City of Albuquerque

June 18, 1999

RE: *Conceptual Grading and Drainage Plan for Department of Corrections, Tract 12A, Cavan Sunport Centre (L16/D23) Submitted for Site Development Plan for Building Permit Approval, Engineer's Stamp Dated 5/27/99.*

Sheet Title **PRELIMINARY**
GRADING & DRAINAGE PLAN

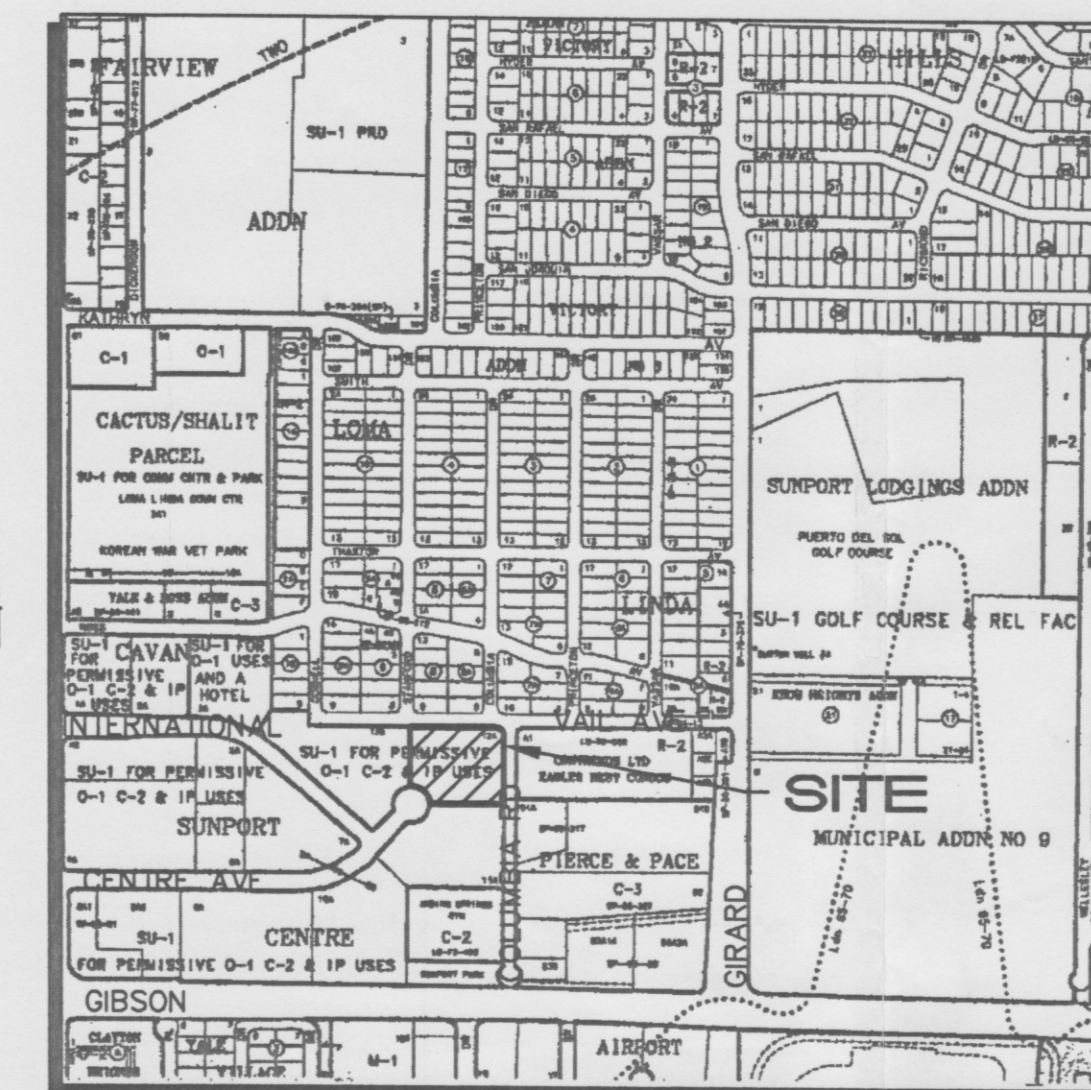
Please be advised, however, that markups have been provided by City Transportation to the Architect regarding the Traffic Circulation Layout. A copy of the letter is attached. If this causes changes to the drainage plan, an updated plan will be required.
